From: [REDACTED]
Sent: 10 July 2023 22:56
To: Planning
Subject: Planning Application Comments - 3/2023/0457 FS-Case-530625447

Planning Application Reference No.: 3/2023/0457

Address of Development: Overdale

York Lane
Langho BB6 8DT

6767 - P04 Rev L

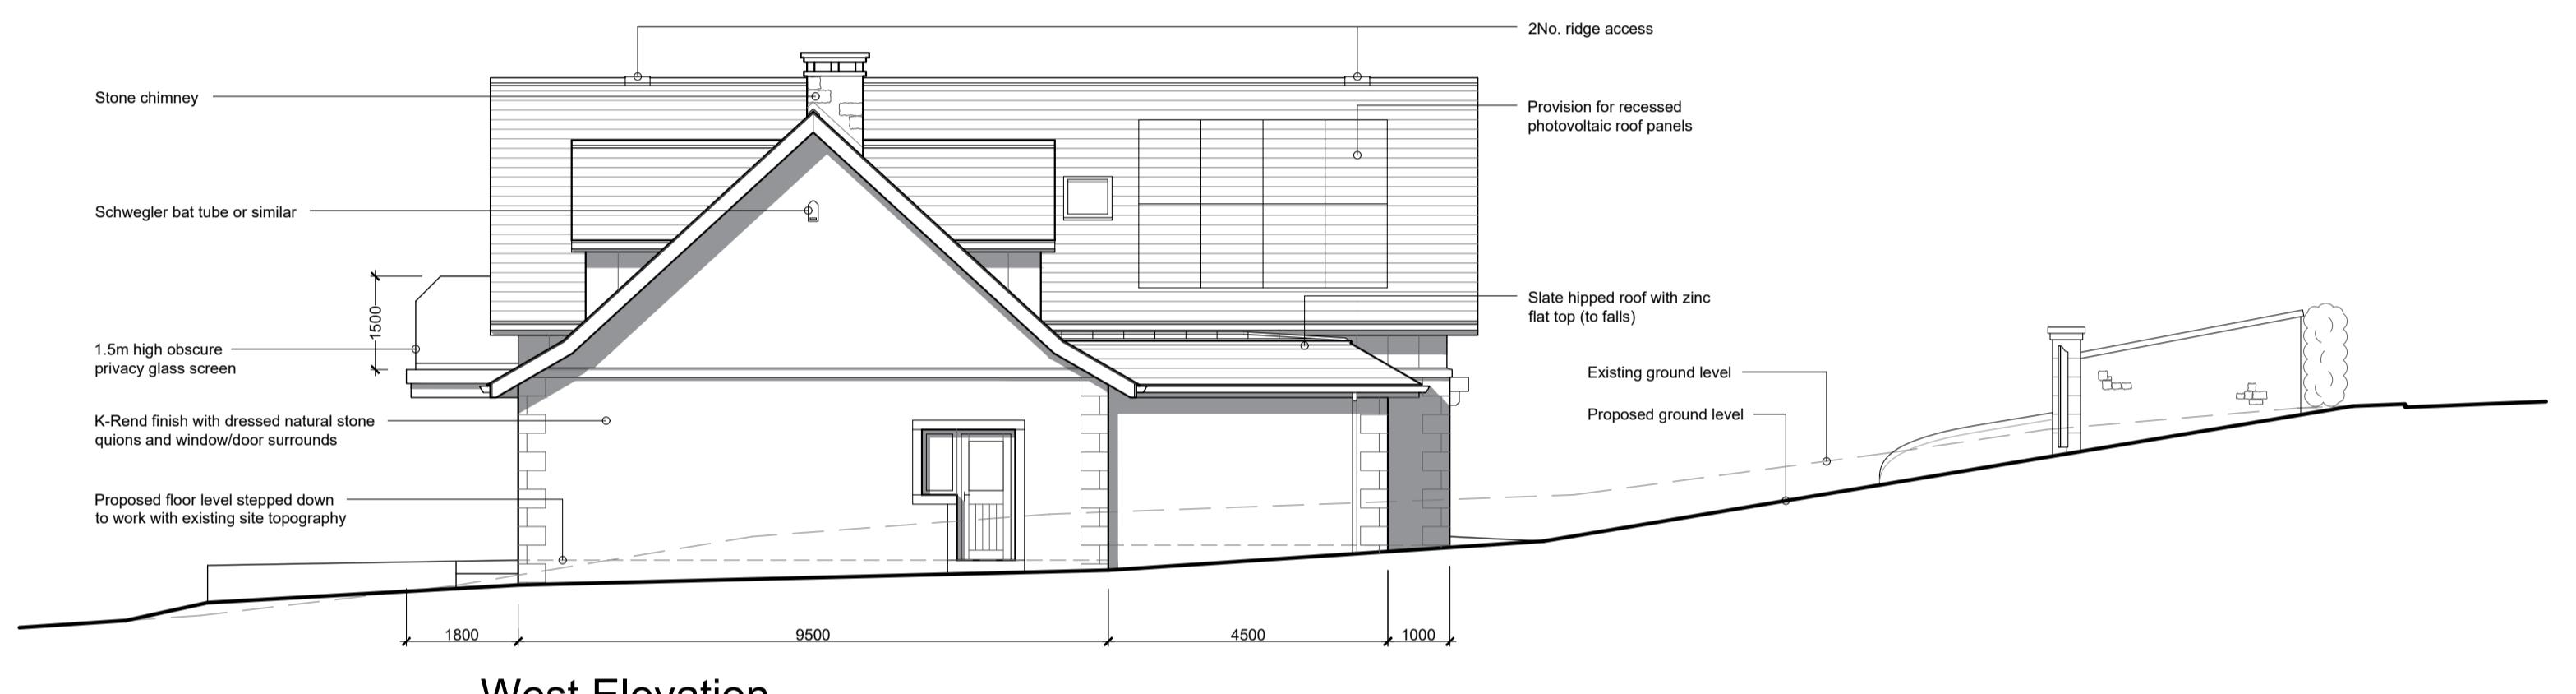
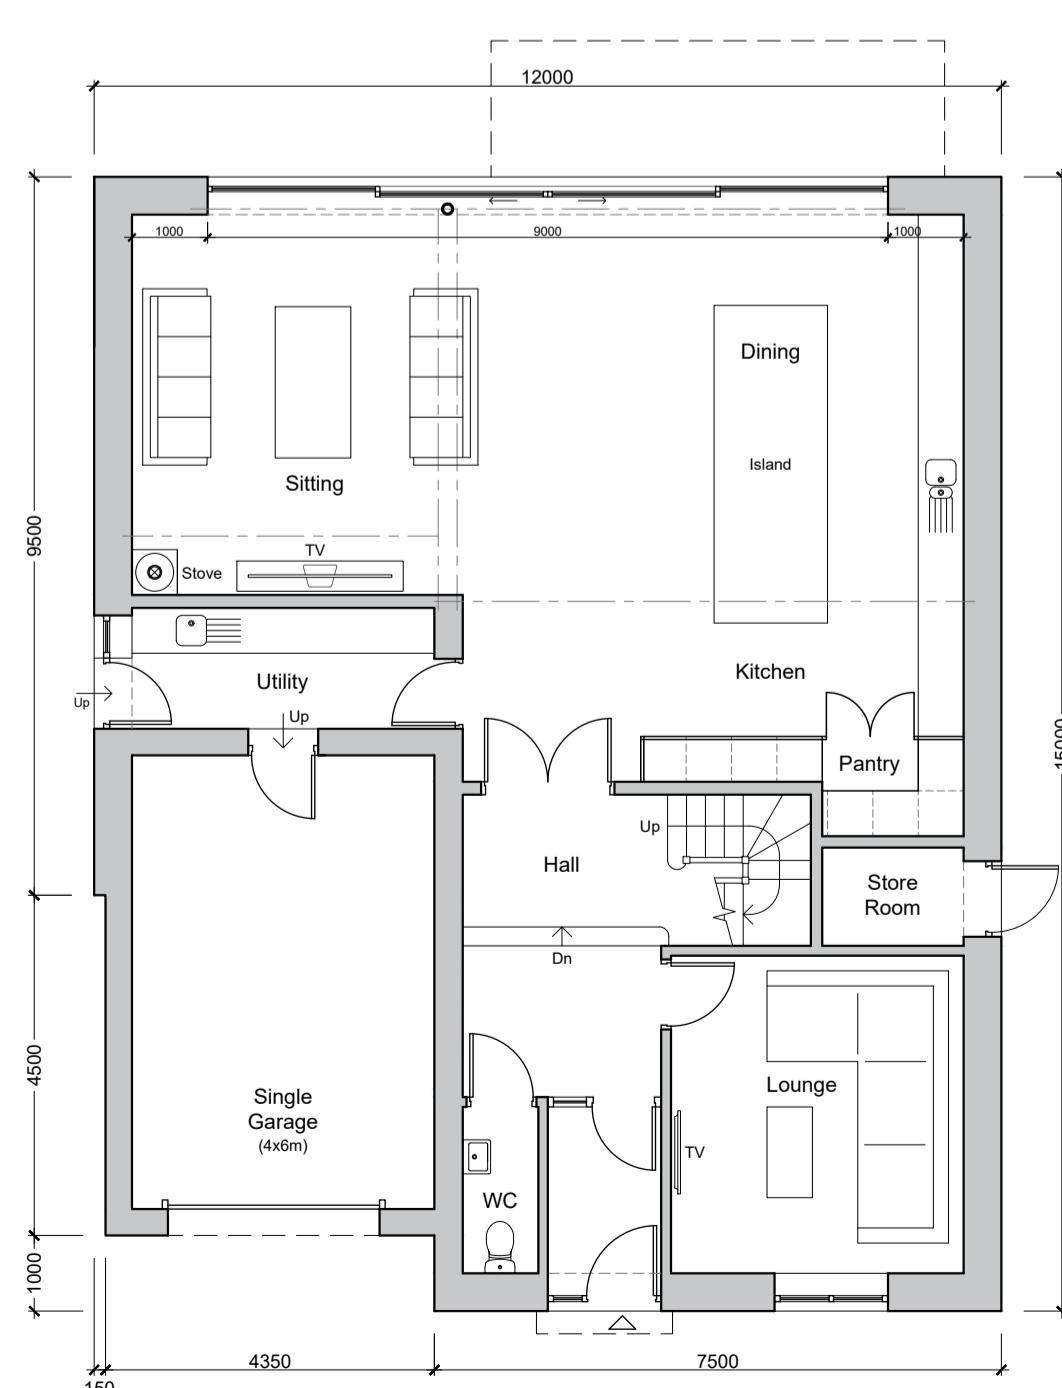
Comments: I strongly object to the proposed plans to build a 2 storey property in the place of the existing single storey dwelling. In addition to the increase in height of the property, the footprint is significantly increased too, further impacting the reduction of light [REDACTED]

Whilst the plans have been revised to reduce the front and back face width, the proposed property is significantly higher than the exiting and previously approved plans. This will have a significant adverse impact on the amount of light [REDACTED] For this reason, I oppose the proposal.

The previously approved plans sited the property much further back on the plot to reduce the impact of the additional storey. My ask is that these plans move the property further back down the plot and site the building at a lower level in the ground.
